**Consultation Response from Alan Smith,  
KC Waste Strategy (Refuse & Recycling)**

**2025/92443 Huddersfield Open Market, Brook Street, Huddersfield, HD1 1DY**

**Responding Ref: WPS 25 062**

05 SOUTH ELEVATION
1:100

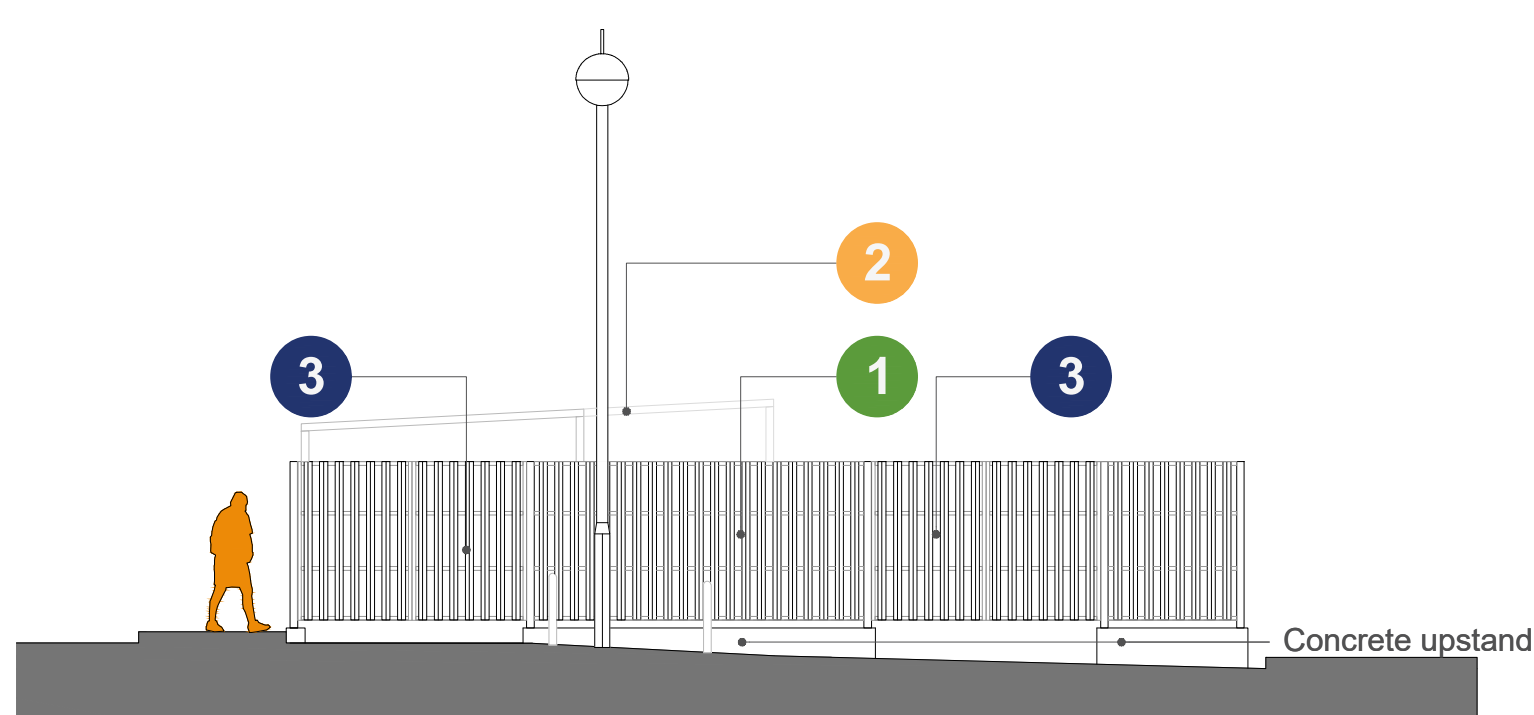
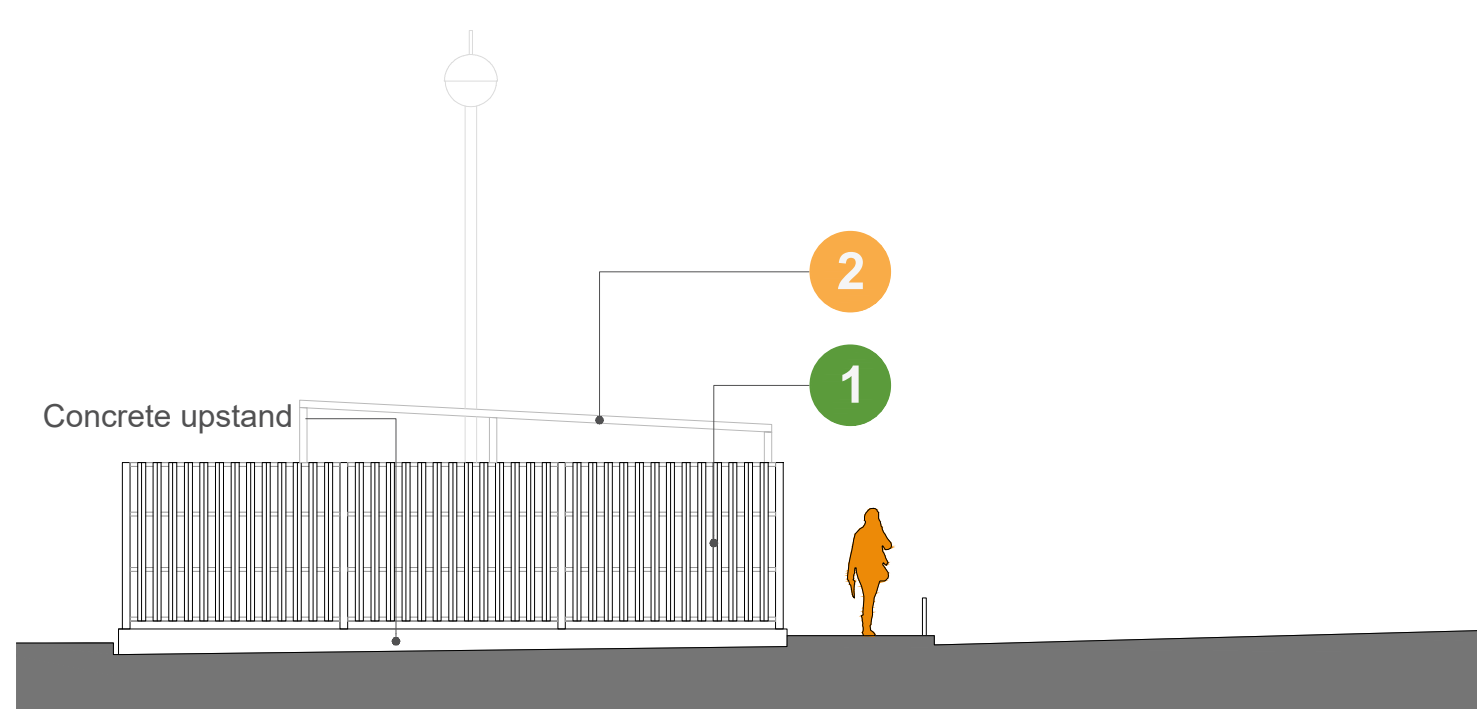
The applicant has submitted a drawing, “*General Arrangement - Storage Compound Plan, Elevations and Sections as Proposed, Dwg No. HMH-GSA-WC-XX-D-A-0415, Rev P02*”.

Further to my comments dated 13<sup>th</sup> October 2025, which still apply to this new submission, the design for the waste compound has changed, as shown below.

An update would be welcomed of the Waste Management Strategy in Section 4.8 of the ‘Access and Building Strategies’ to confirm that the new proposal is acceptable to the WCA.
